Your Ref: OWPC18208
Our Ref: AW/85/18/HH 20-03-2018
Please ask for:
Andrew Wood

Two storey side extension, front porch & external cladding to front, side & part rear elevations. This application may affect the character & appearance of the Craigweil House Conservation Area.

54 Kingsway Aldwick

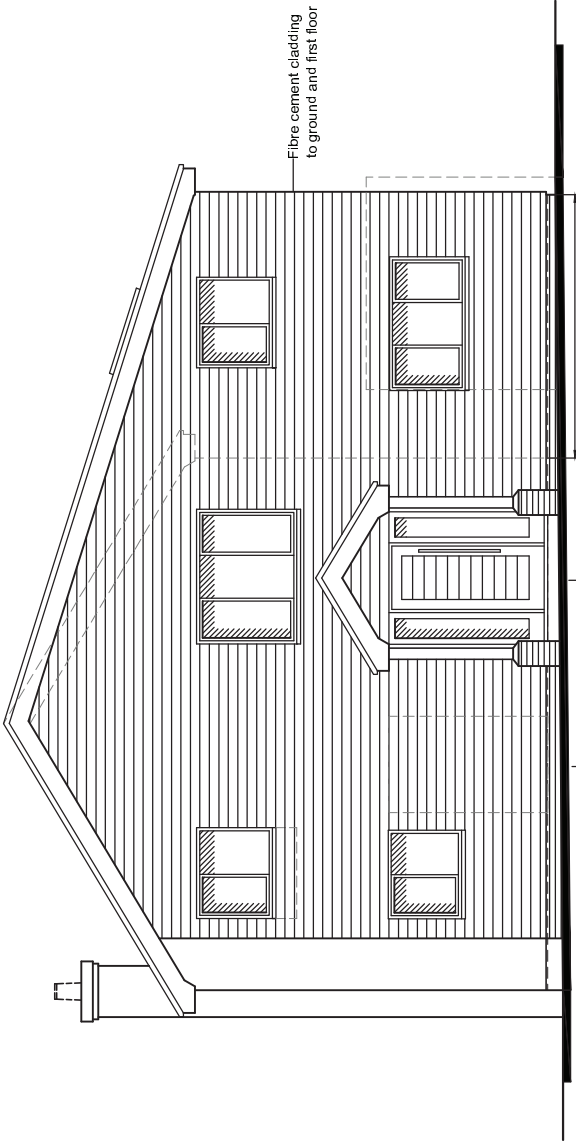
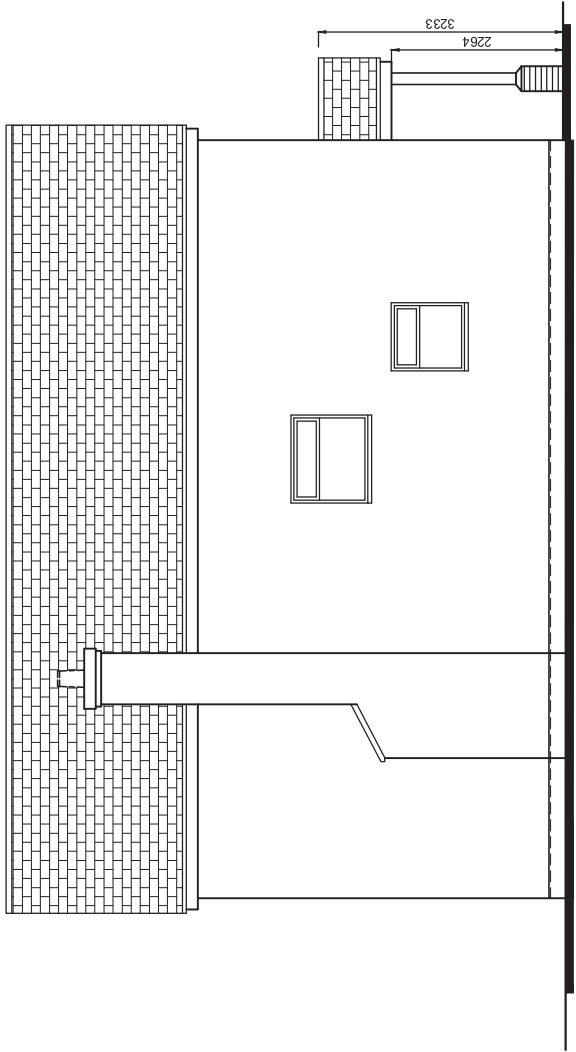
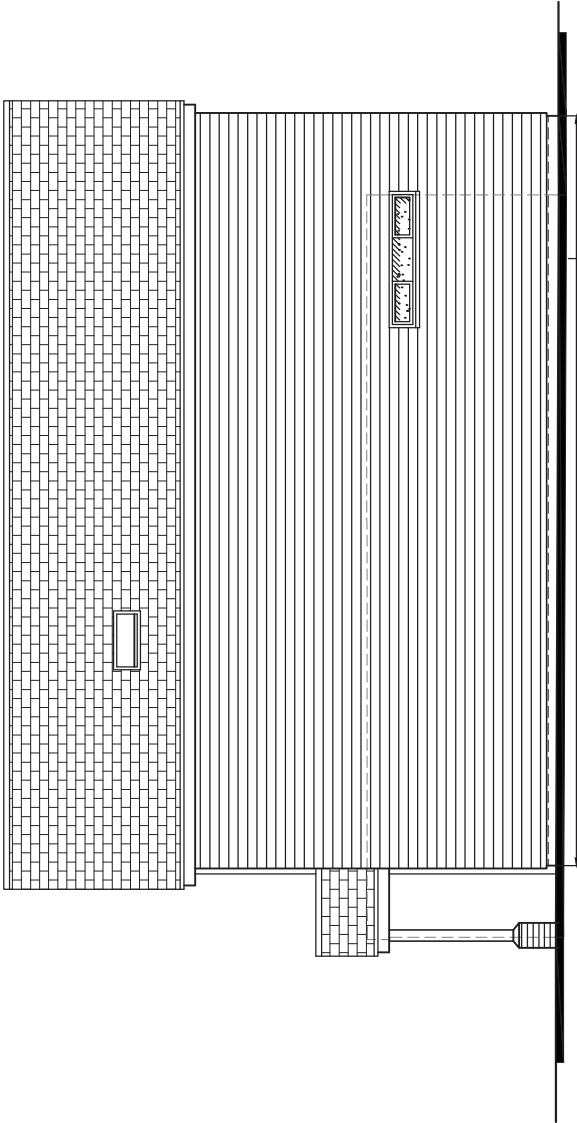
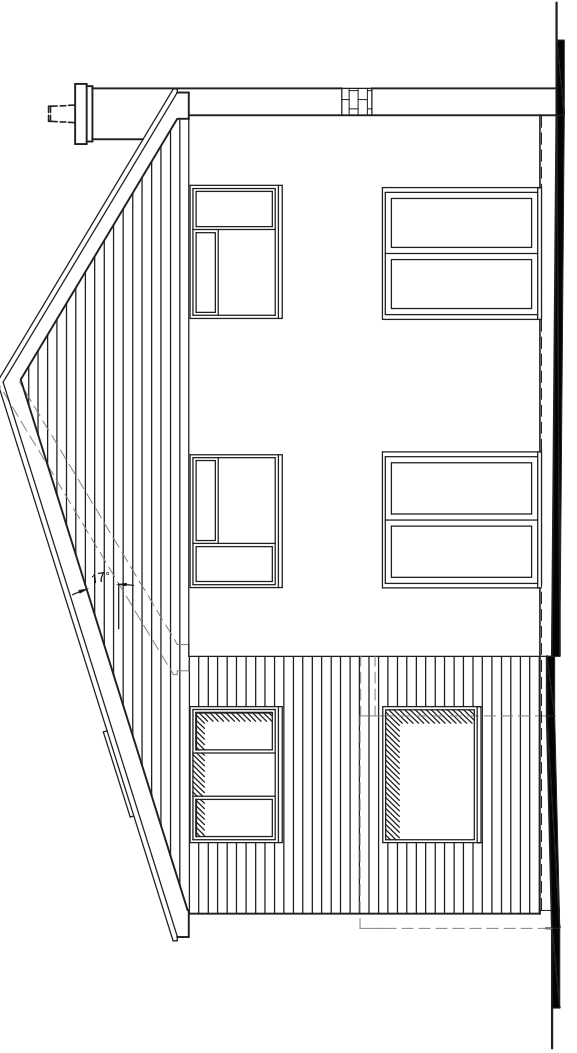
*Blocks all light to my dining room & side path & a lot to my kitchen. Proposed extension would be right on or up to boundary.
Not in keeping with neighbourhood, estate & local environment.
I would not give permission to access my property during any building works or after.*
